Kirklees Council
Planning and Development Service
PO Box 1720
Huddersfield
HD1 9EL

Date: 07-Nov-2022
Our Ref: 2022/91598

Discharge of conditions 3 (Construction Management Plan), 4 (Construction Environmental Management Plan), 5 (road condition survey), 6 (Remediation Strategy), 9 (coal legacy) , 11 (estate roads), 12 (drainage under highway), 13 (highway retention), 14 (arboricultural method statement), 15 (Ecological Design Strategy), 16 (drainage scheme) and 17 (temporary drainage) of previous permission 2020/92067 for erection of 30 dwellings

former, Stile Common Infant & Nursery School, Plane Street, Newsome, Huddersfield, HD4 6DF

APPENDIX A – SITE LAYOUT PLAN

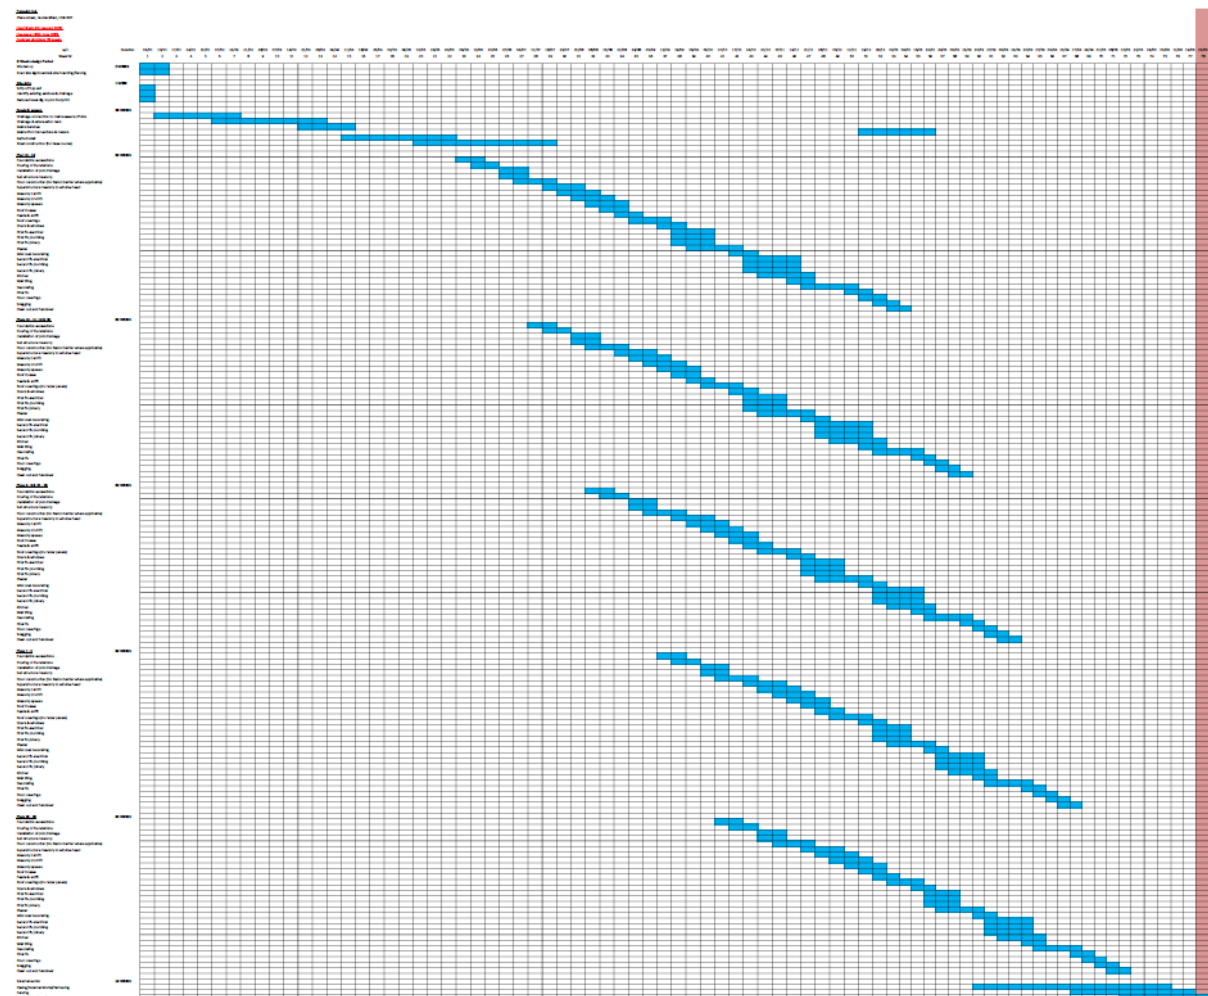
- The condition requires details of '*routing of construction traffic to and from the site*'. No plan showing the route for construction traffic is shown. Such a plan should ensure construction vehicles remain on A roads for as long as practical, connecting to a motorway junction, and avoid villages and unsuitable smaller roads.

- A parking area is shown, but no details of the number of spaces it will provide are given. No information is provided on typical and maximum demand, to demonstrate that the parking spaces are adequate, nor is there any consideration of methods to prevent construction staff from parking on the residential Plane Street.
- Inadequate commitment to wheel washing and avoiding mud on the road is provided. A wheel-washer should be provided at all times, with its location to be shown on plan.
